The SLP – Heronscourt & Colville Gardens (the RAs) response to the Applicant's Revision 2.0 of Site Specific Plan APP Document 8.58 dated March 2020

General

## **Appendix B – Construction and Reinstatement Plans**

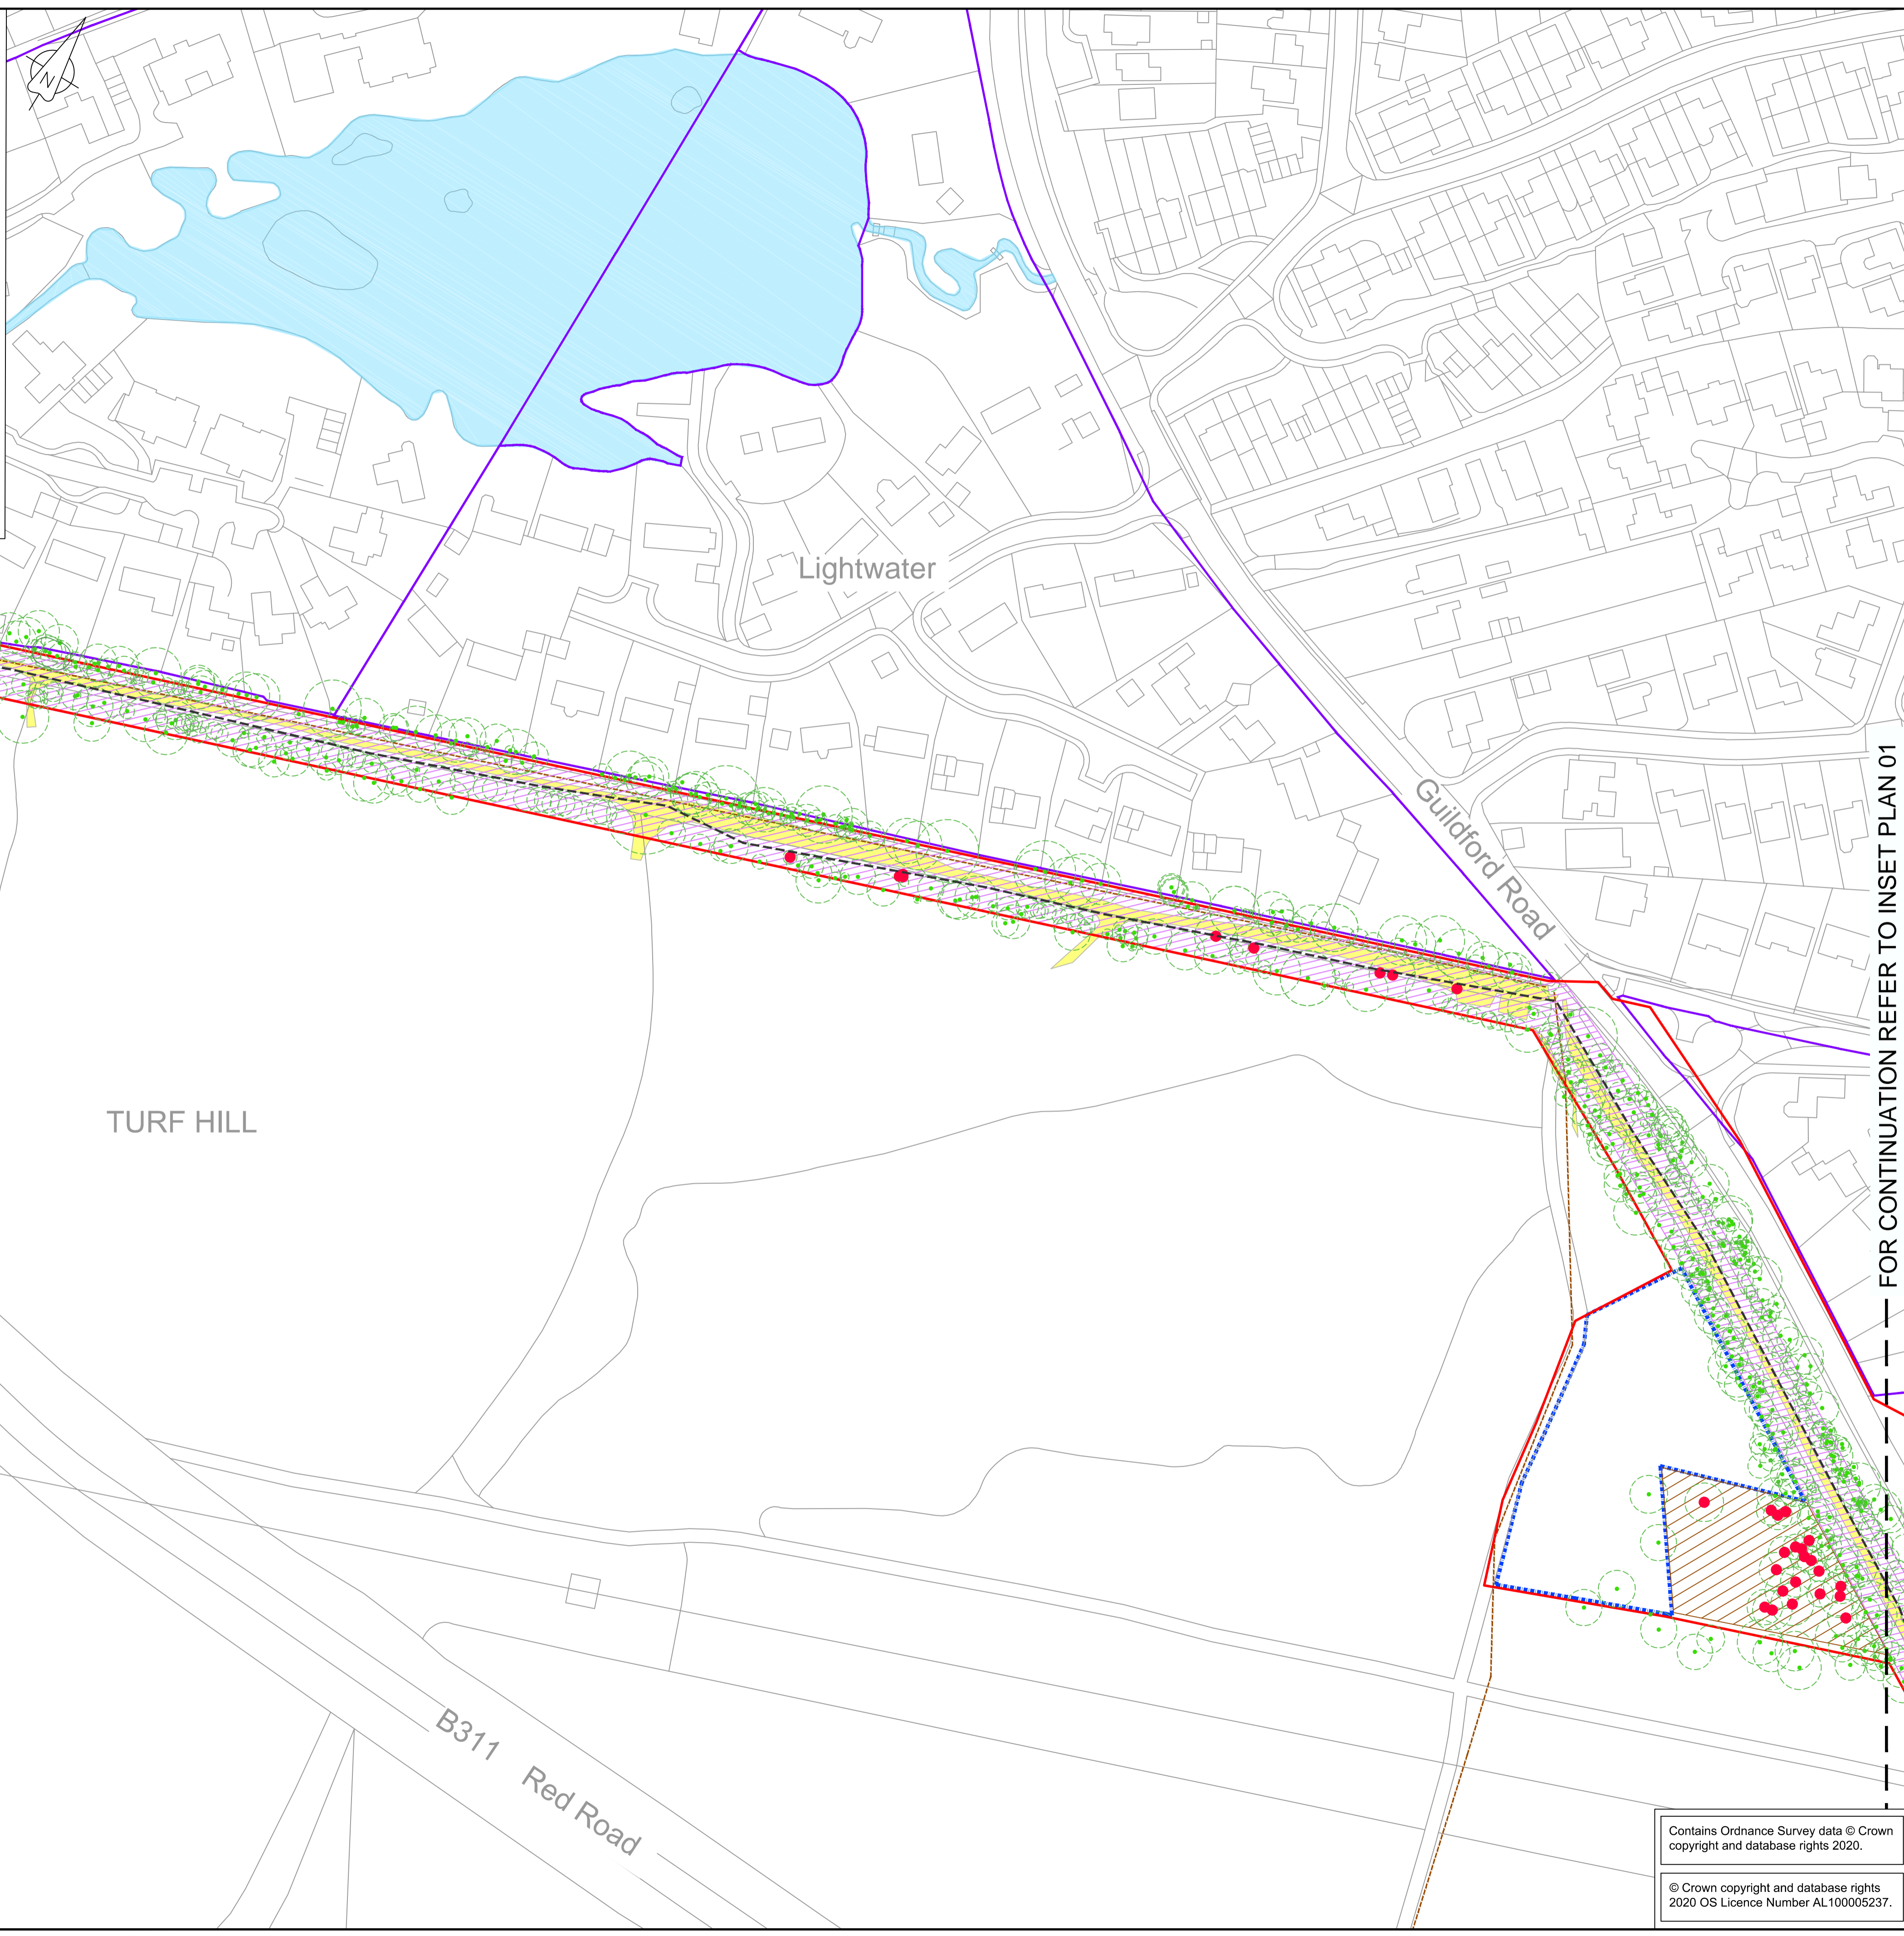
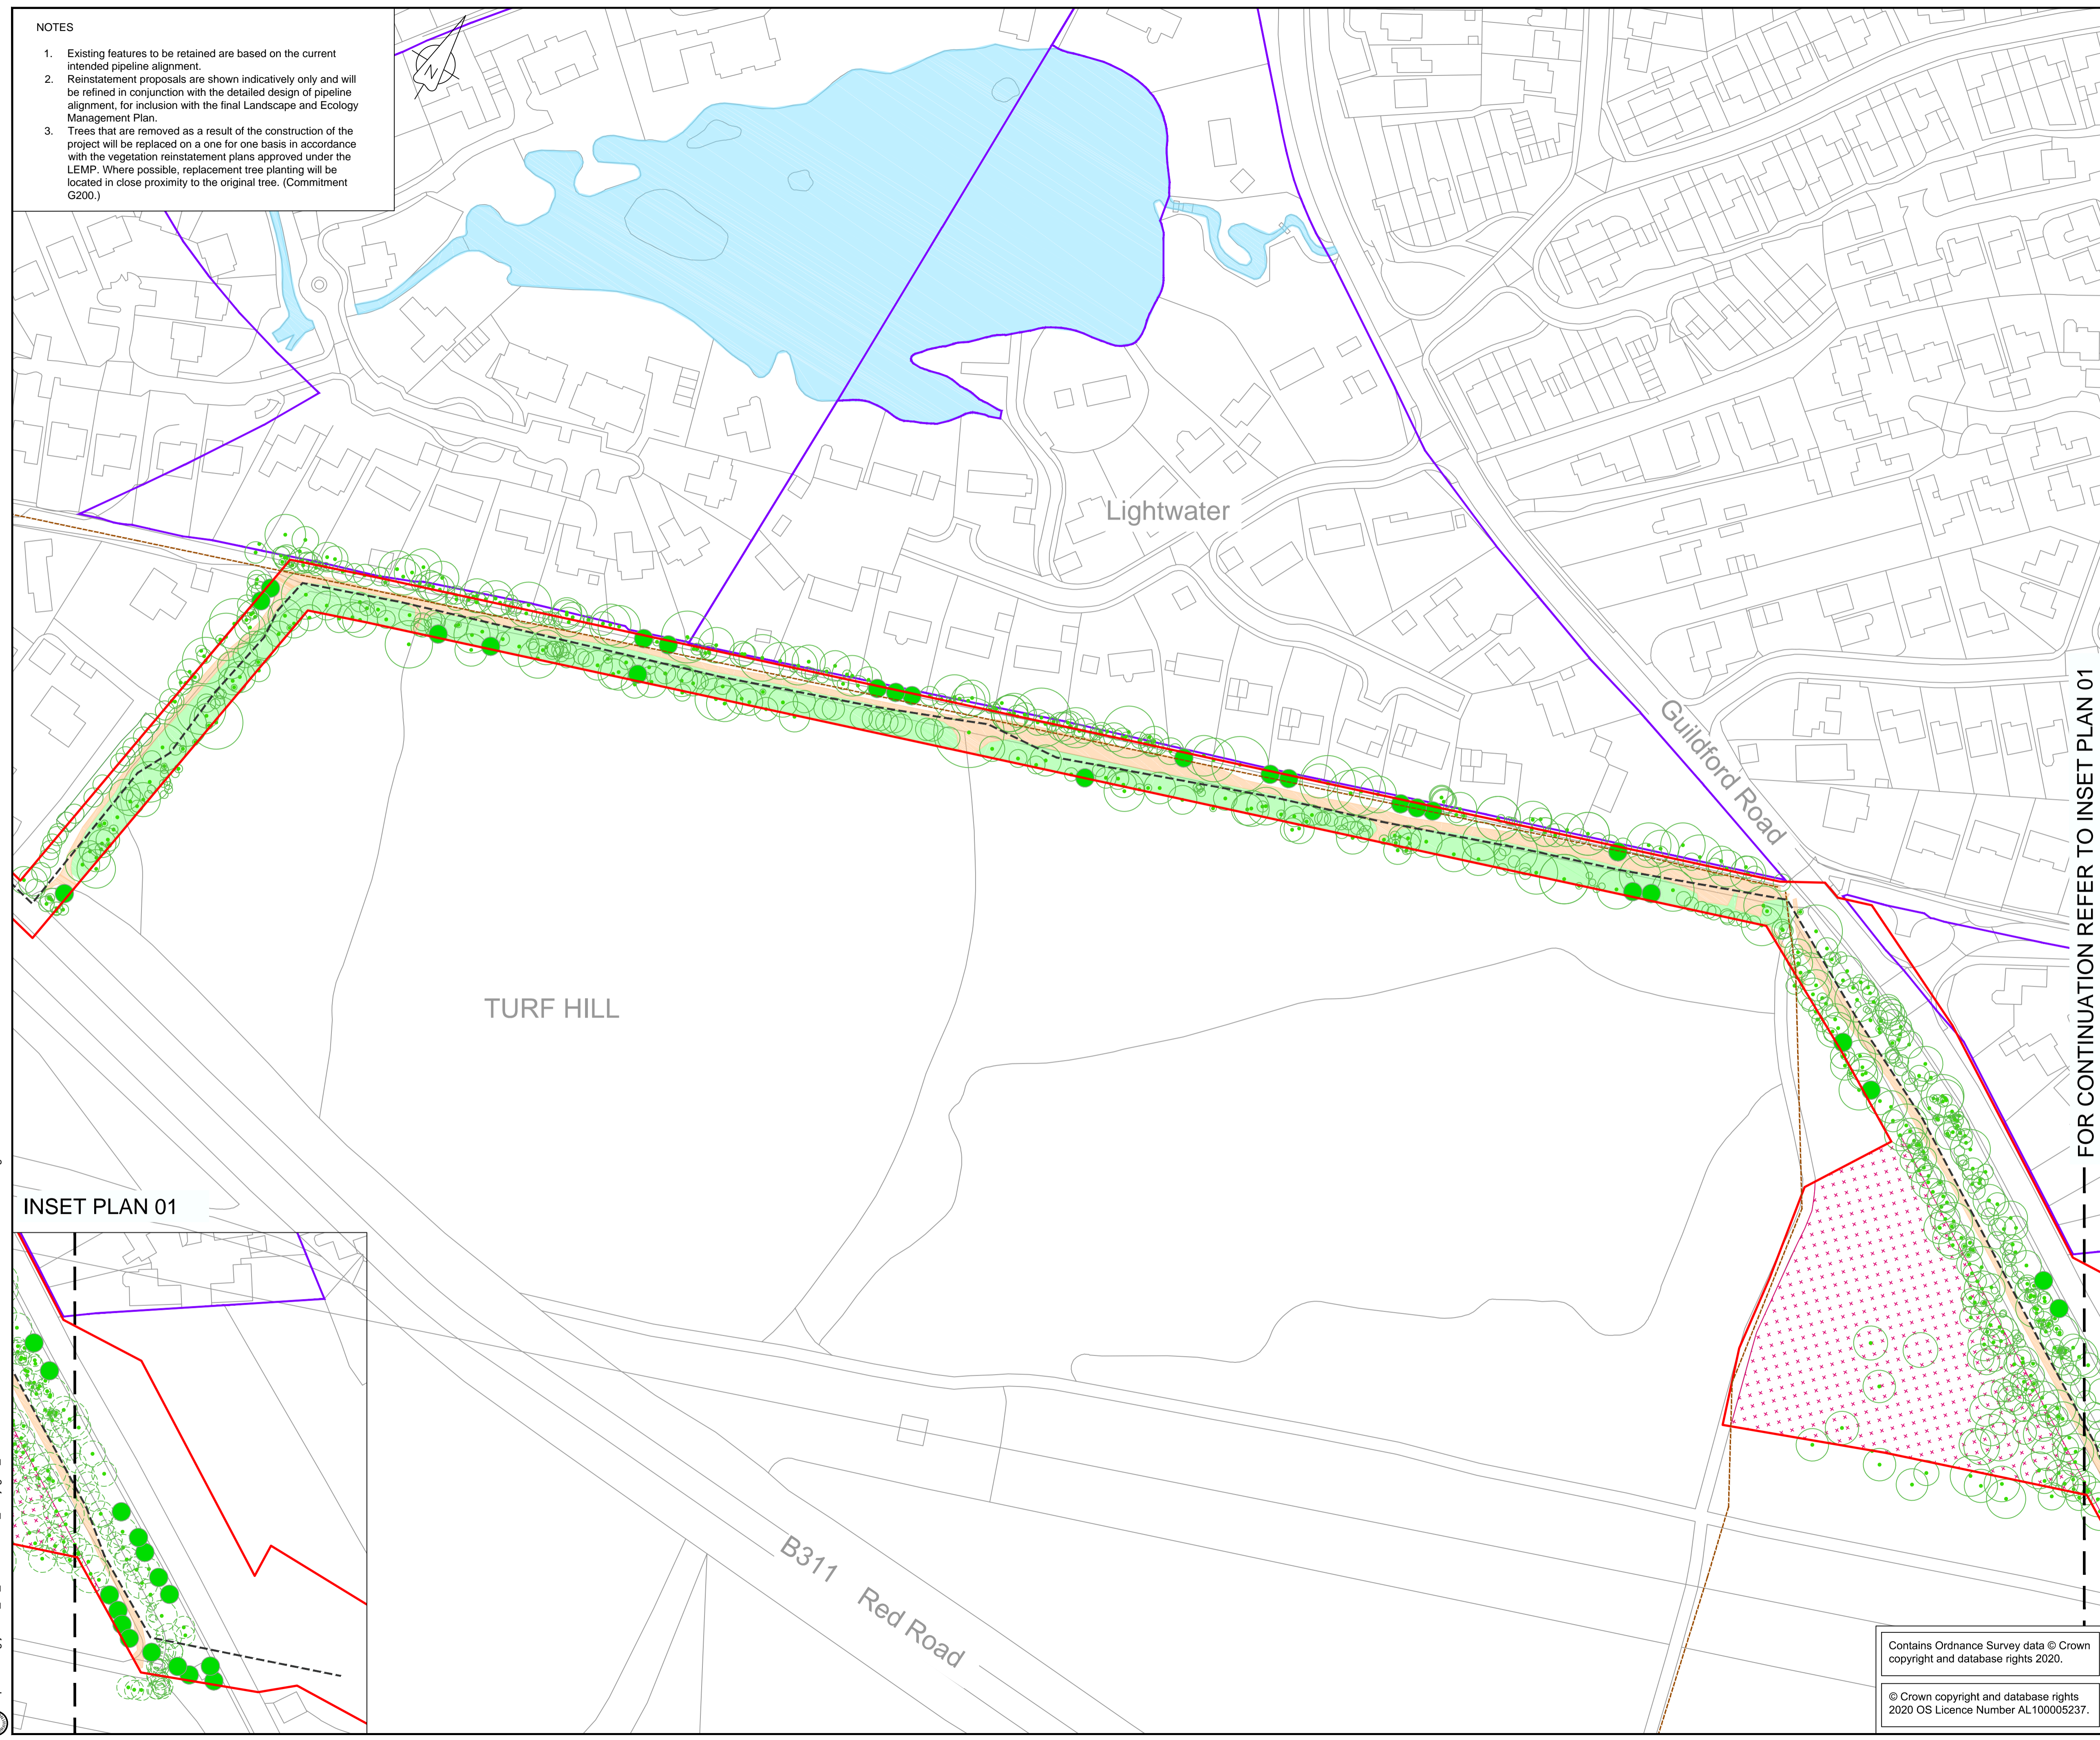
There are obvious comments which need to be made;

- F1a is not a straight pathway and curves away out of sight from the Guildford Road, northwards at approximately midpoint and pipelines do not bend in straight lines!

- it makes no mention of the water main, unless the dotted red line is meant to indicate its position and which, in the absence of any actual survey, can only be an optimistic guess.

- even given that the RPAs of retained and bordering trees are shown using minimum calculations, the proposed line cuts through a considerable number of them. In some cases, it runs nearly through the middle of the indicated RPA. No apology is made for reiterating a statement made in the RAs response to the first SSP, that an RPA is not 'a no damage likely to be done' but is more 'a tree is unlikely to die immediately and may eventually recover.'

- at approximately midpoint, along the northern boundary, the line comes extremely close to a number of properties, in particular Nos 29 & 31 of Heronscourt and No 20 of Colville Gardens, where there are very substantial trees bordering F1a.
